DRB Application No.: 07DRB-00023 (P&F) Project # 1005258  
Project Name: LANDS OF CHRIS CHAVEZ  
Agent: Angela Blair Phone No.: 328-4109

**CITY OF ALBUQUERQUE  
PLANNING DEPARTMENT  
January 17, 2007  
DRB Comments**

**Re: Tract A, Map 37, Martineztown/p&f**

PURPOSE OF PLAT:

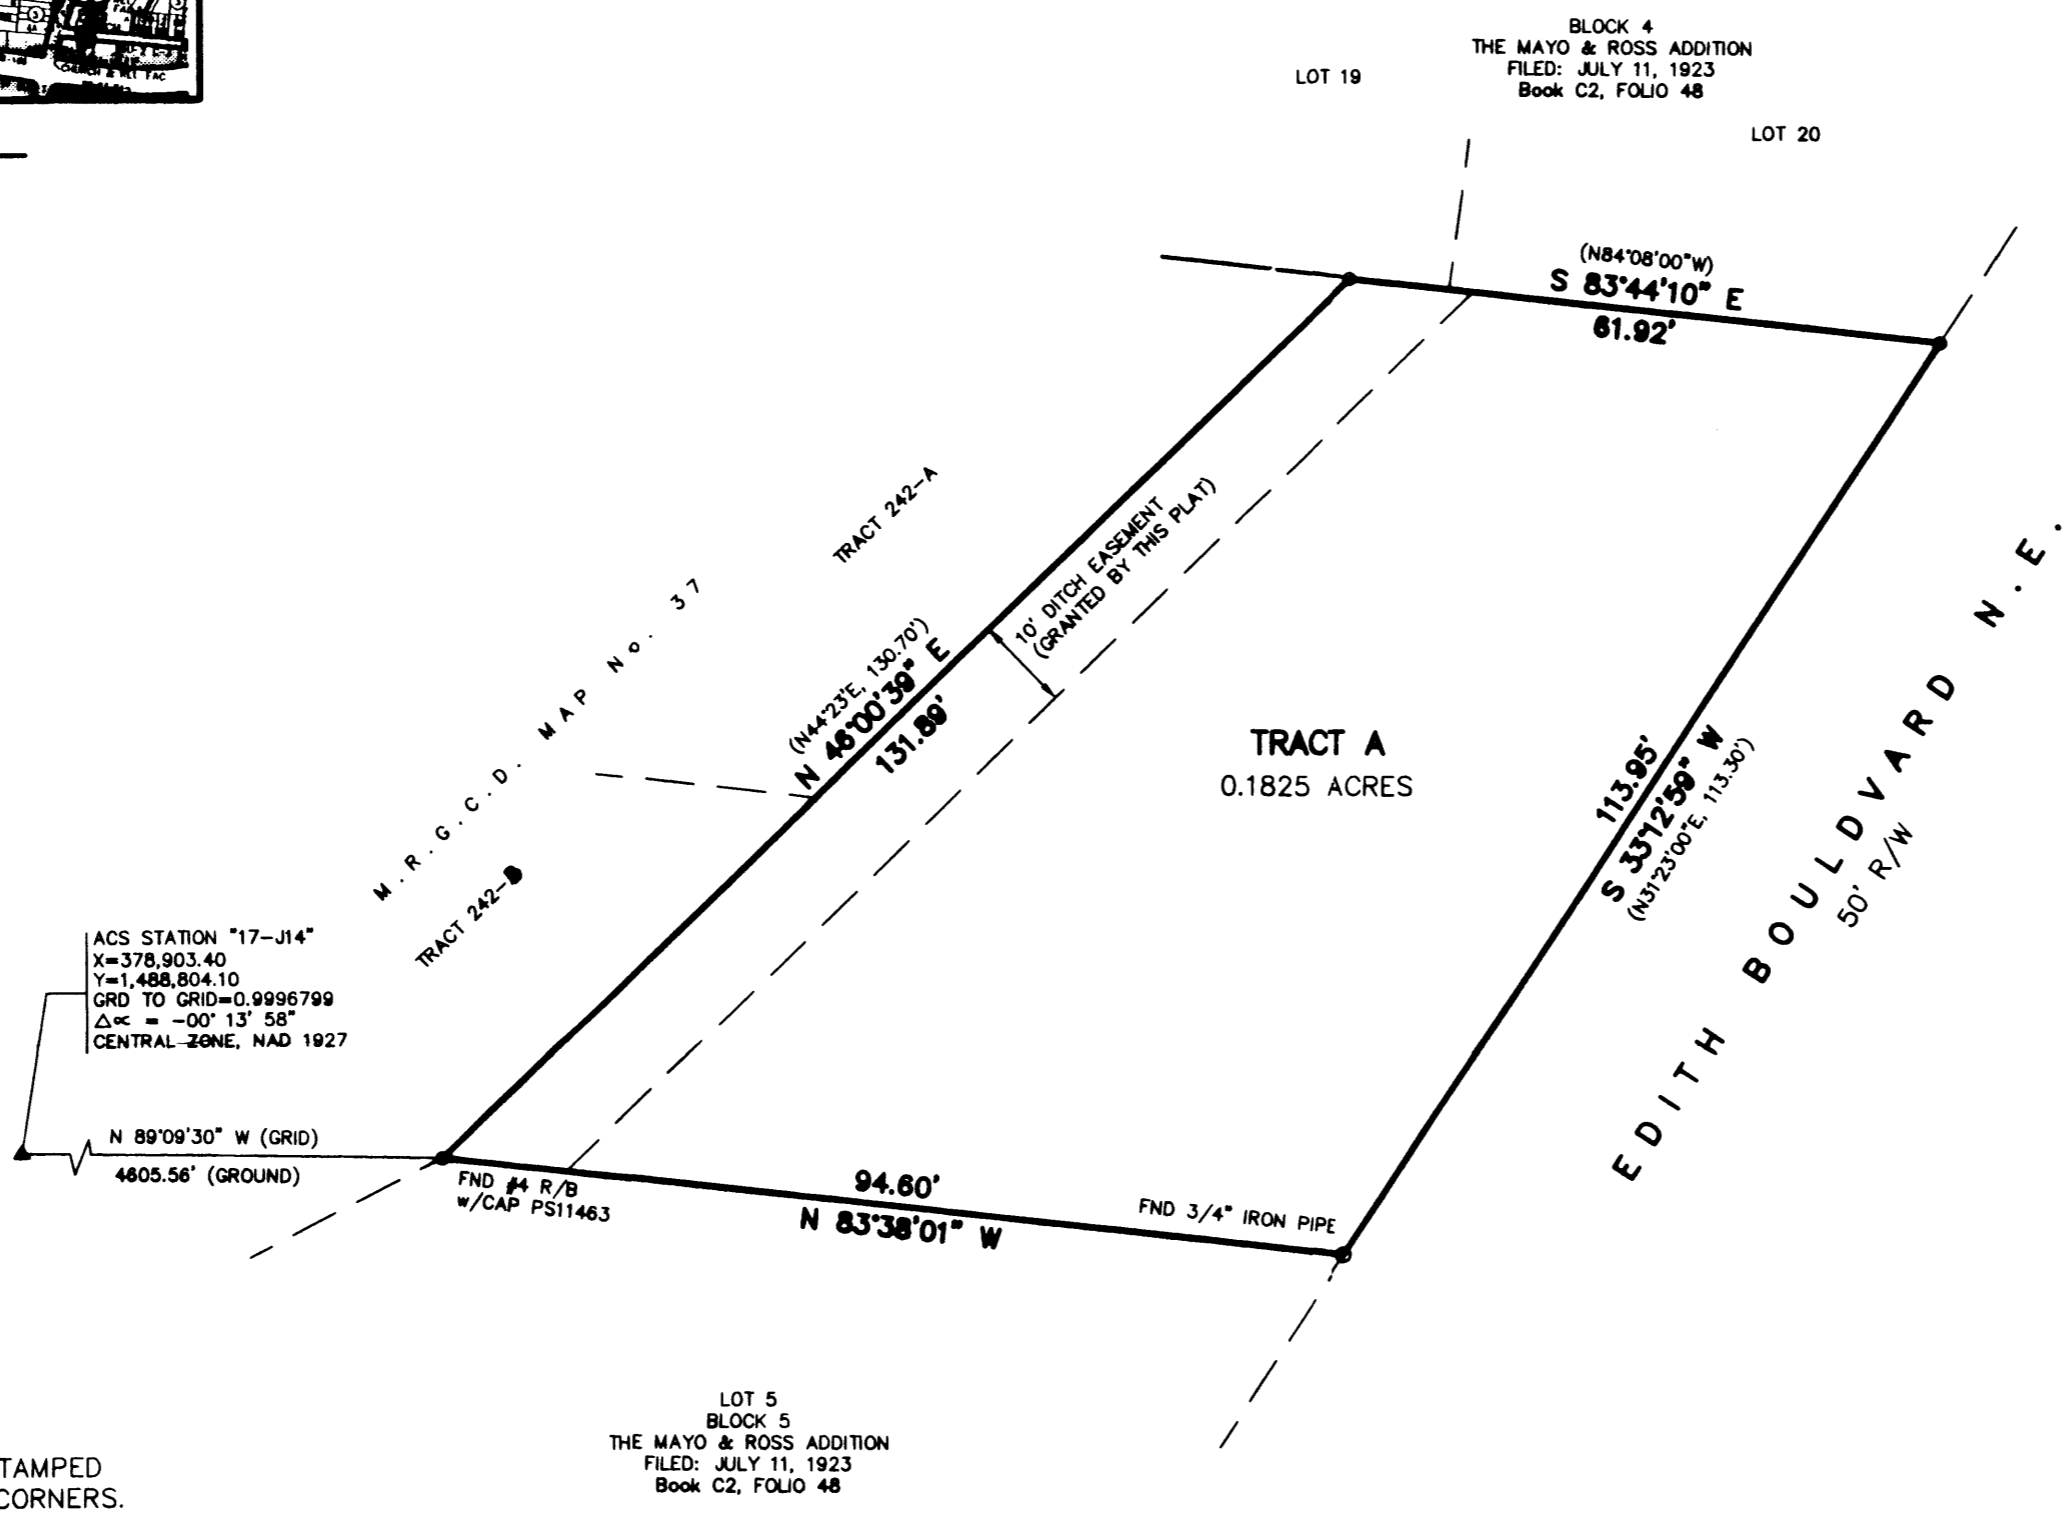
TRANSPORTATION: dedication along Edith

AGIS dxf is not approved.

A vacation is required for the removal of the ditch easement.

The site is zoned SU-2/NRC, which corresponds R-2 zone for residential development, and would require a 15 foot rear yard setback. Therefore, any dwelling unit would need to be outside of the 10 foot wide ditch easement.
